DELEGATED HOUSEHOLDER DECISION

Item No.	Report of the Head of Planning, Sport and Green Spaces
Address	39 FALLING LANE YIEWSLEY
Development:	Single storey rear extension and conversion of roof space to habitable use to include a rear dormer, 2 front rooflights and conversion of roof from hip to gable end
LBH Ref Nos:	71343/APP/2015/4062
Drawing Nos:	45G Rev. B 45H Rev. B Location Plan (1:1250) 39K Rev. A 39A Rev. A 39B Rev. A 39C Rev. A 39D Rev. A 39E Rev. A 39F Rev. A 39J Rev. A

PROPOSED GROUND FLOOR PLAN  
SCALE:-1:100

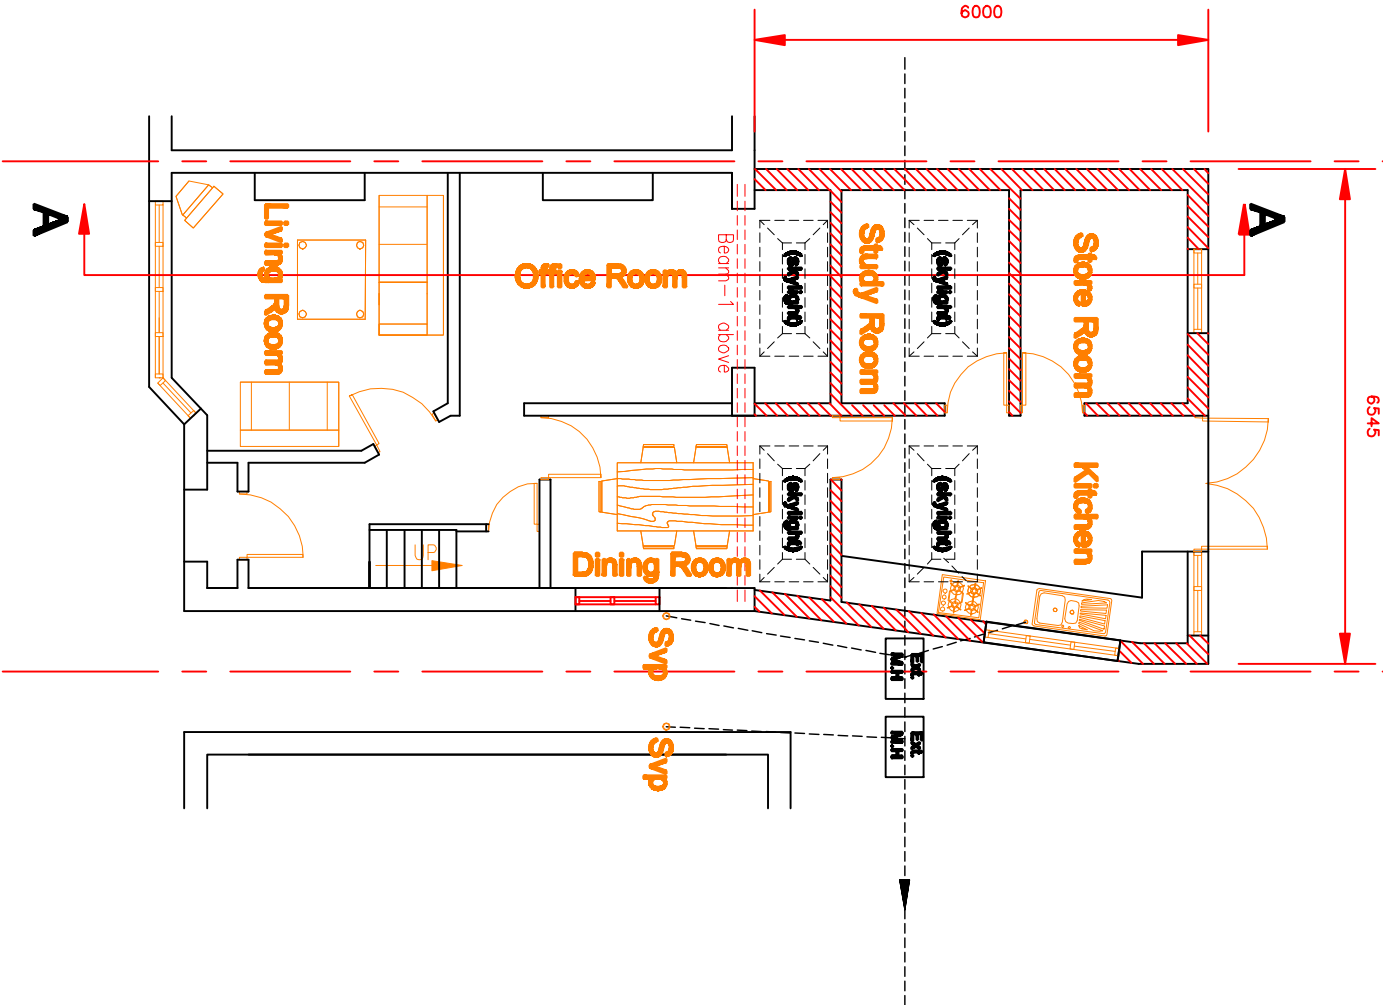
The application site forms part of a semi-detached dwelling and benefits from ample amenity space to the front and rear. The proposed single storey extension would measure 6m in depth, and would be sited to the rear of the dwelling. It is considered as the proposed extension would be sited to the rear, it would not result in a harmful impact on the character and appearance of the original dwelling and the surrounding area.

The adjoining neighbours to either side at Nos. 37 & 41 Falling Lane, do not benefit from any form of extension. The proposed single storey rear extension would therefore project 6m beyond both adjoining properties rear walls. No. 37 Falling Lane is the adjoining semi,

and therefore a 6m deep extension protruding beyond their rear wall along the shared boundary would appear overdominant and overbearing and would result in a significant loss of their residential amenities and levels of light.

The adjoining neighbour to the north side at No. 41 is separated by a driveway and also an existing garage along the shared boundary measuring approximately 3m high. The proposed extension which although could be considered overbearing and overdominant by virtue of its depth, it is considered not to have a greater impact upon their residential amenities and light levels than the existing garage.

The proposed extension is therefore considered to have an adverse impact upon the residential amenities and light levels of the adjoining semi-detached dwelling at No. 37 Falling Lane by reason of its size, scale and depth and would therefore be contrary to Policies BE20 & BE21 of the Hillingdon Local Plan: Part Two Saved UDP Policies (November 2012) and the HDAS Supplementary Planning Document.

The proposed single storey rear extension, by virtue of its size, scale, bulk, depth and proximity, would be detrimental to the amenities of the adjoining occupier at 37 Falling Lane by reason of overdominance, overshadowing, visual intrusion, loss of light and loss of outlook. Therefore the proposal would be contrary to policies BE19, BE20 and BE21 of the Hillingdon Local Plan: Part Two - Saved UDP Policies (November 2012) and the Council's adopted Supplementary Planning Document HDAS: Residential Extensions.

PROPOSED LOFT FLOOR PLAN
SCALE:-1:100

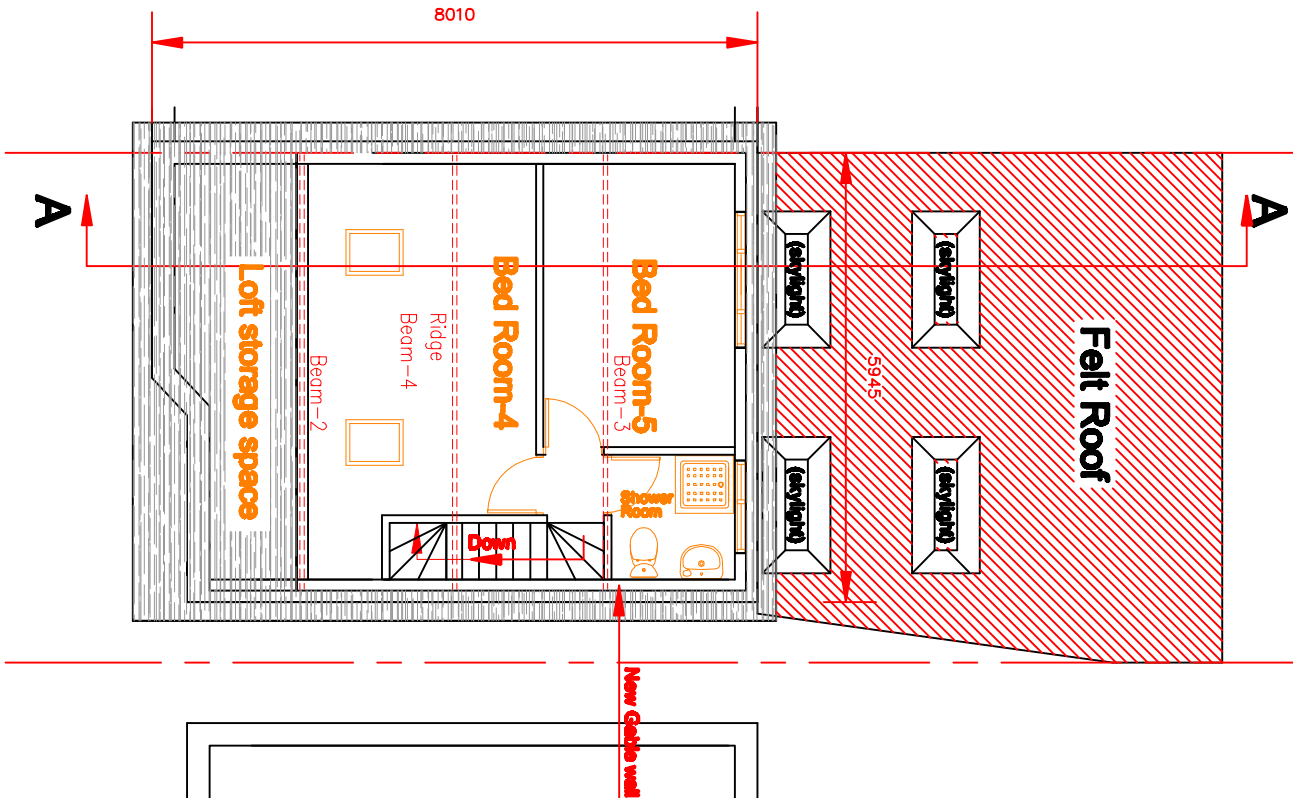
The proposed dormer would be set below the ridge and above the eaves by 300mm, and set in from the sides by 250mm. The proposed dormer would extend approximately the full width and height of the original and extended dwelling including the gable end following the conversion. As the property would also be described as a larger semi-detached dwelling the set ins of the dormer would not be considered sufficient to appear secondary or proportionate to the main roof slope and would give the appearance of an effective flat roofed third storey which would have a harmful impact on the character and appearance of the existing house and street scene.

The roof alteration/extensions, by reason of the hip to gable end roof design and the size, scale, bulk, and design of the rear dormer window would fail to harmonise with the architectural composition of the original semi-detached dwelling, would be detrimental to the character, appearance and symmetry of the pair of semi-detached houses of which it forms a part and to the visual amenities of the street scene and the surrounding area. Therefore the proposal would be contrary to Policy BE1 of the Hillingdon Local Plan: Part One - Strategic Policies (November 2012), Policies BE13, BE15 and BE19 of the Hillingdon Local Plan: Part Two - Unitary Development Plan Saved Policies (November 2012) and the adopted Supplementary Planning Document HDAS: Residential Extensions.

PROPOSED ROOF PLAN
SCALE:-1:100

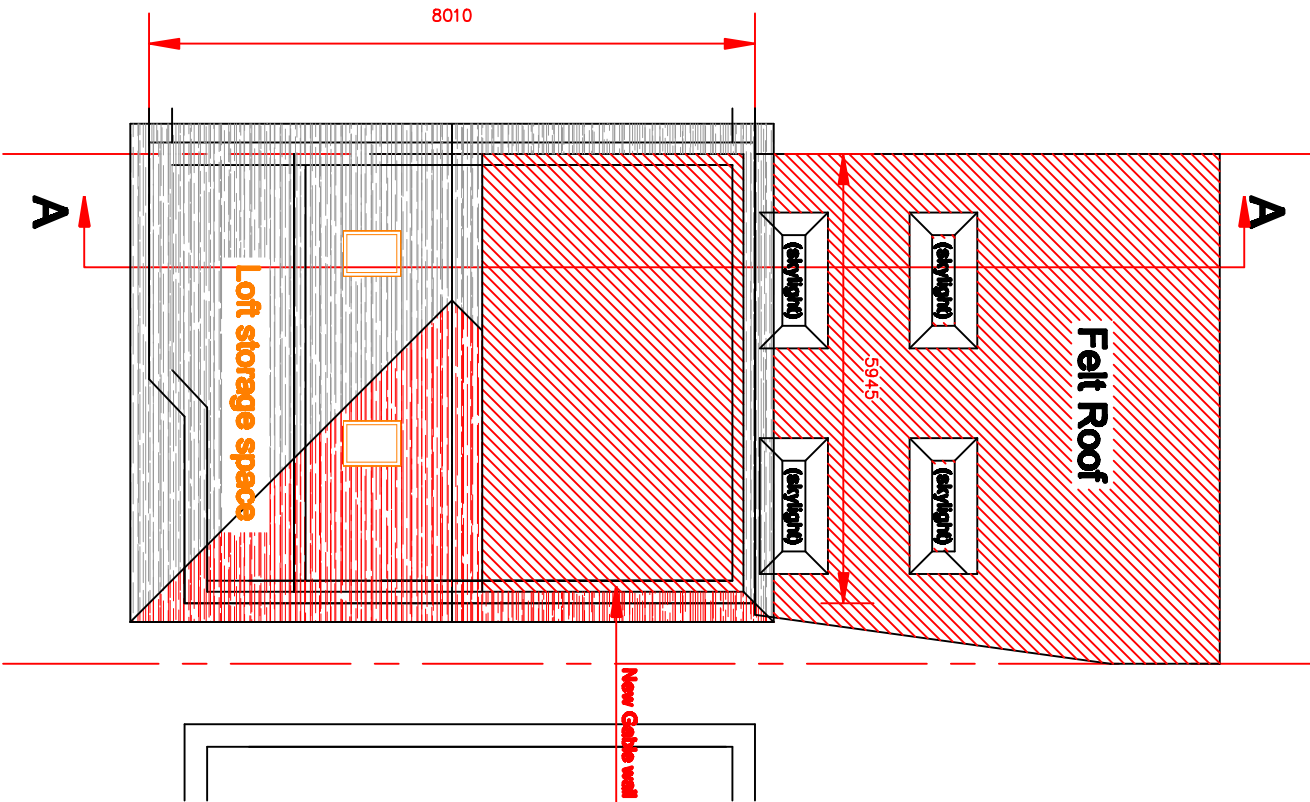
The property is characterised by a hipped roof, which is consistent with the adjoining semi-detached properties along Falling Lane, and the adjacent Gordon Road. It is considered the proposed hip to gable conversion would unbalance the overall appearance between the application site and the adjoining semi, which retains its hipped roof appearance, and would result in an harmful impact on the character and appearance of the street scene.

The proposed dormer and hip to gable conversion would have a harmful impact on the character and appearance of the surrounding area and would be contrary to Policies BE13, BE15, BE19 of the Hillingdon Local Plan: Part Two Saved UDP Policies(November 2012) and the HDAS Supplementary Planning Document.
